Rumford House
Church Road
Yapton
Arundel
West Sussex BN18 0EW

3rd July 2022

Ref Y/68/22/L and Y/67/22/HH

I hope it is acceptable to address my comments on the above two applications in this one letter. As far as I can see, the applications are identical, both amended versions of application Y/36/22/HH which was withdrawn in May 2022.

Title
SITE PLANS

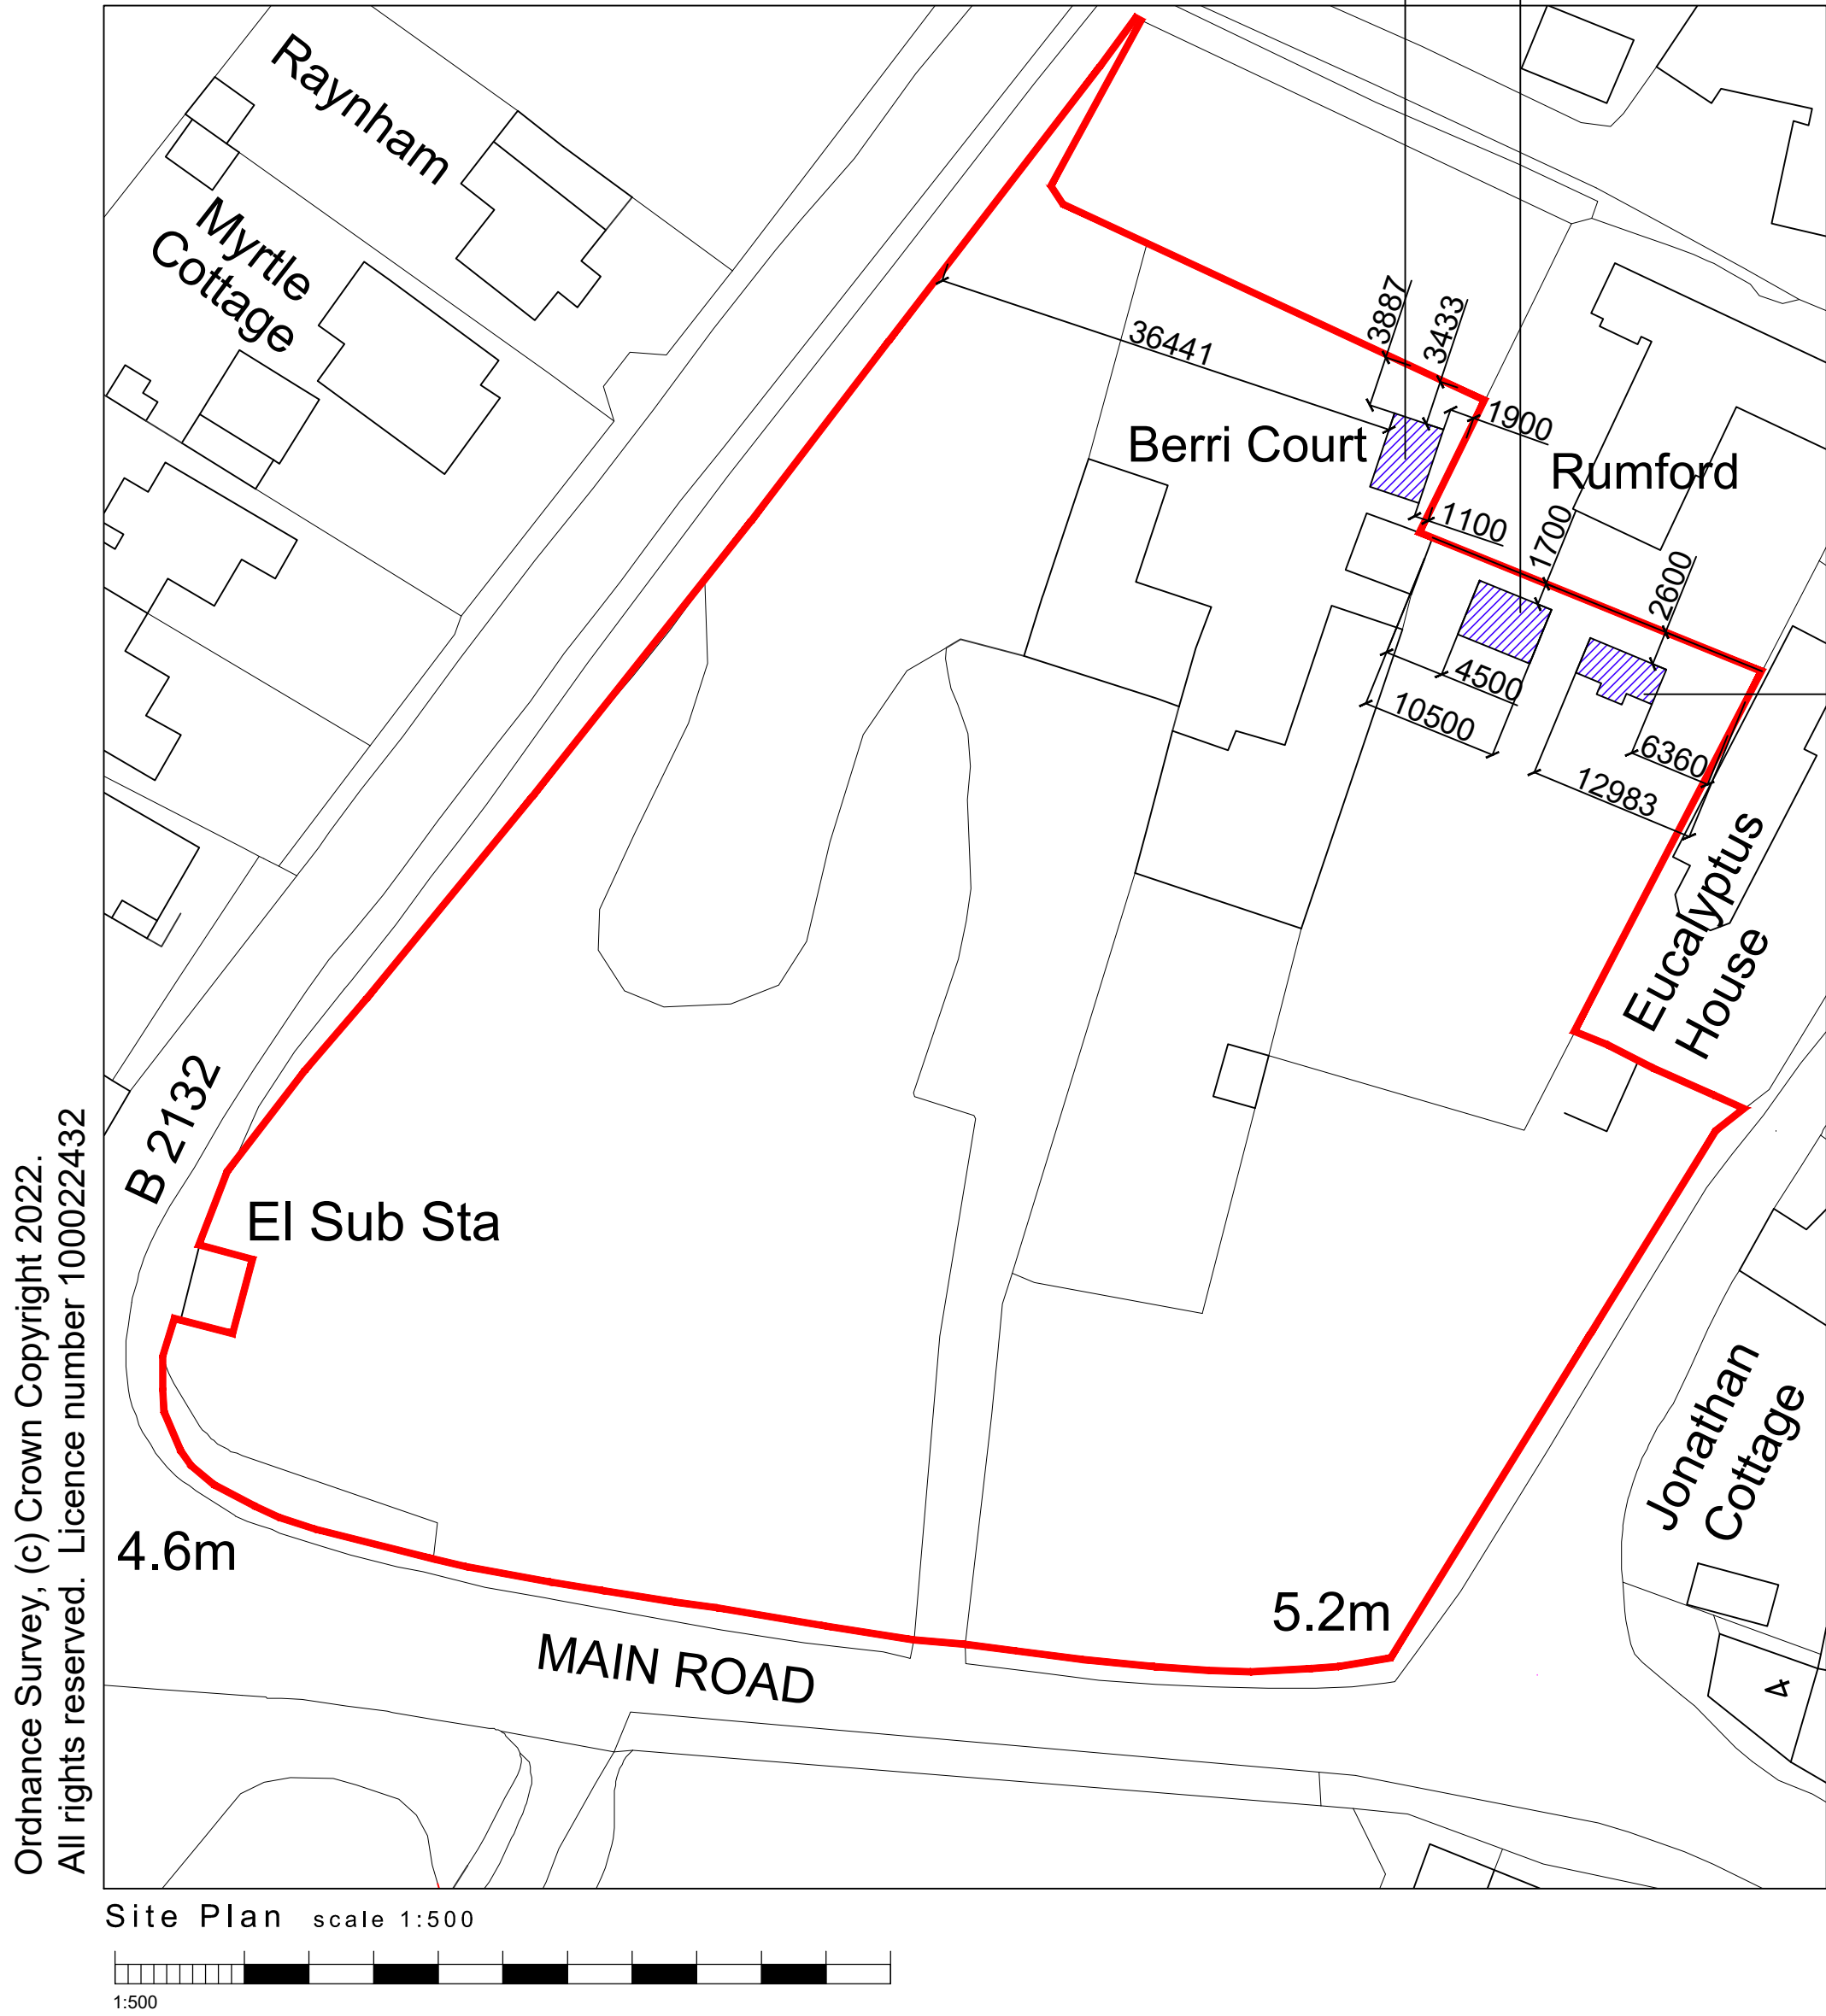
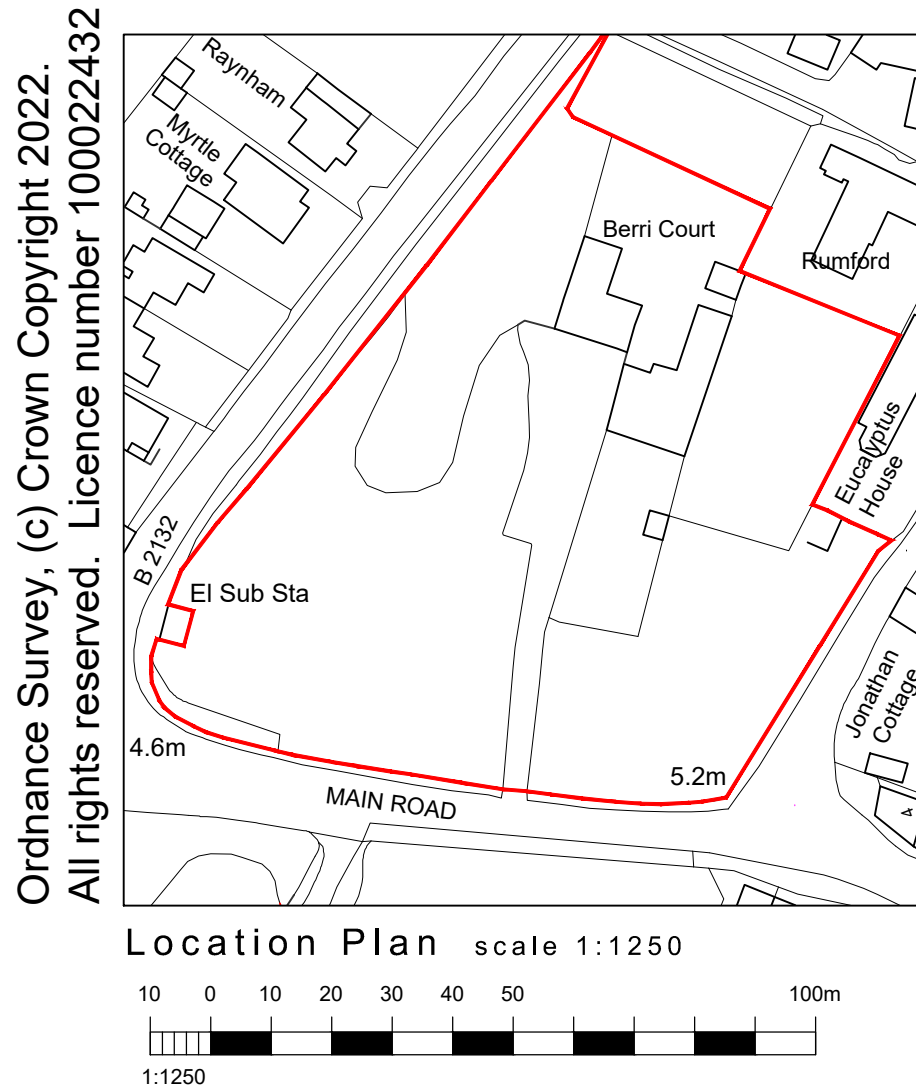
- correctly showing the existing footprint to my property (Rumford House) and
- moving the proposed new structures (workshop, gym/hobby room and greenhouse) slightly further away from the boundary between our respective properties by a distance of between 31cm and 75.9cm.

1. Neither application appears to have included a Tree Report. (My understanding is that the Arun Tree Officer requested one for the previous application). The Site Plans still do not show the location of trees closest to the proposed structures.

4. The re-siting of the proposed structures away from the boundary wall could be improved by moving both the workshop and the gym/hobby room a minimum of 2.6m away from the boundary wall, as per the proposed greenhouse which is lower in height and

lighter in construction compared with them; but, again, I would question why it is proposed that all three structures are concentrated against the one boundary between our respective properties and all in proximity to my house.
